City of Portland, Maine - Building or Use Permit Application

Permit No: 03-1197	Issue Date:	CBL: 327A A007001
------------------------------	--------------------	-----------------------------

Past Use: Office Space/Commercial	Proposed Use:	Permit Fee: \$1,893.00	Cost of Work: \$208,000.00	CEO District: 1
Proposed Project Description: New 4,000sq.ft. Addition with Office Renovations		FIRE DEPT: <input type="checkbox"/> Approved <input type="checkbox"/> Denied	INSPECTION: Use Group: Type	
		Signature:	Signature:	
PEDESTRIAN ACTIVITIES DISTRICT (P.A.D.) <input type="checkbox"/> <input type="checkbox"/> Approved w/Condition <input type="checkbox"/>

FLOOR PLAN

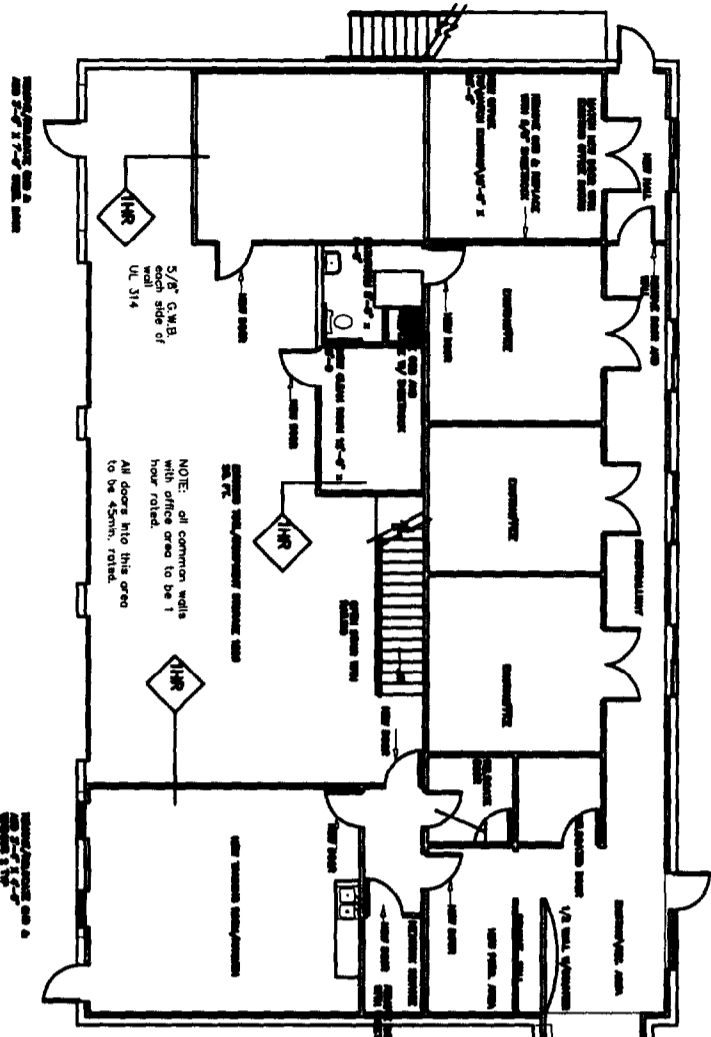
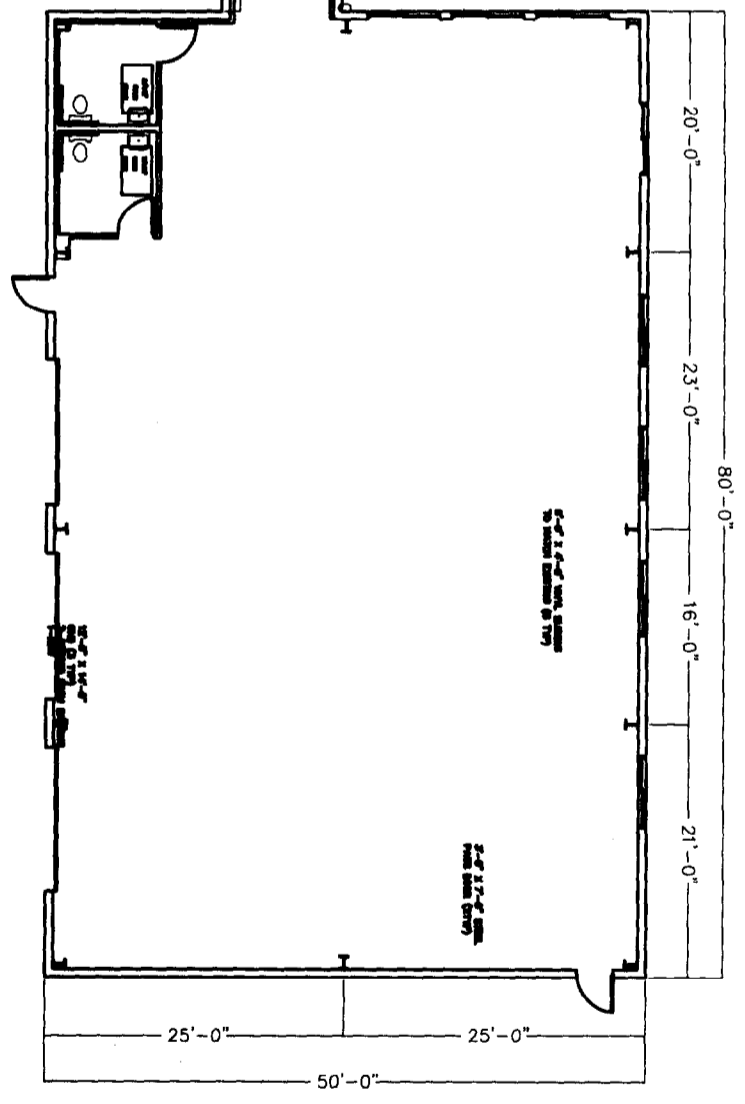
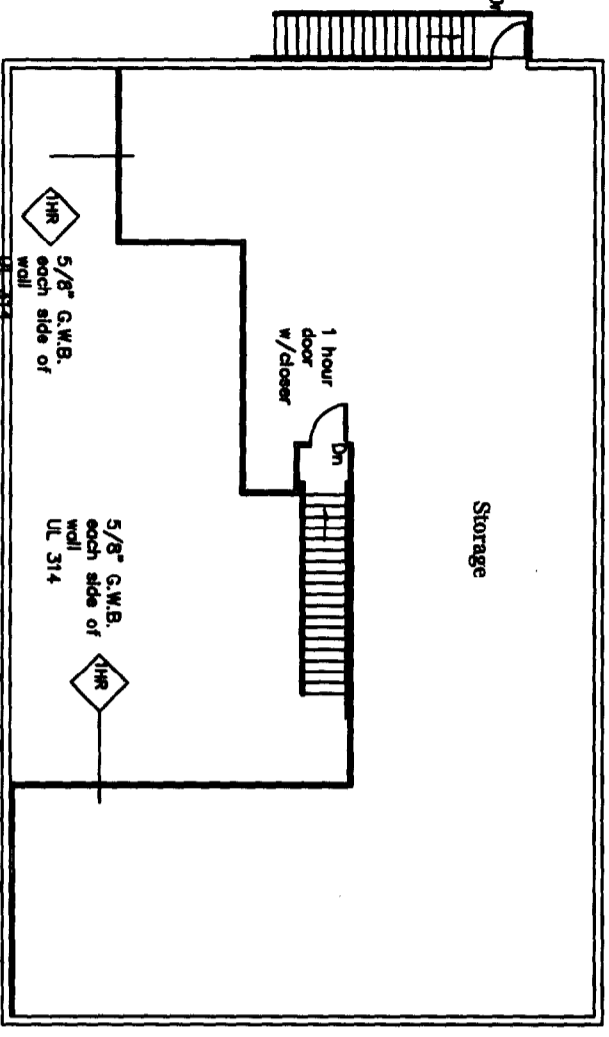
Comments:
11/03/2003-mjn: Needs Fire separation assembly between S and B use group. Needs structural on Masonry wall and special inspection info.
Spoke with Rick Day at Patco
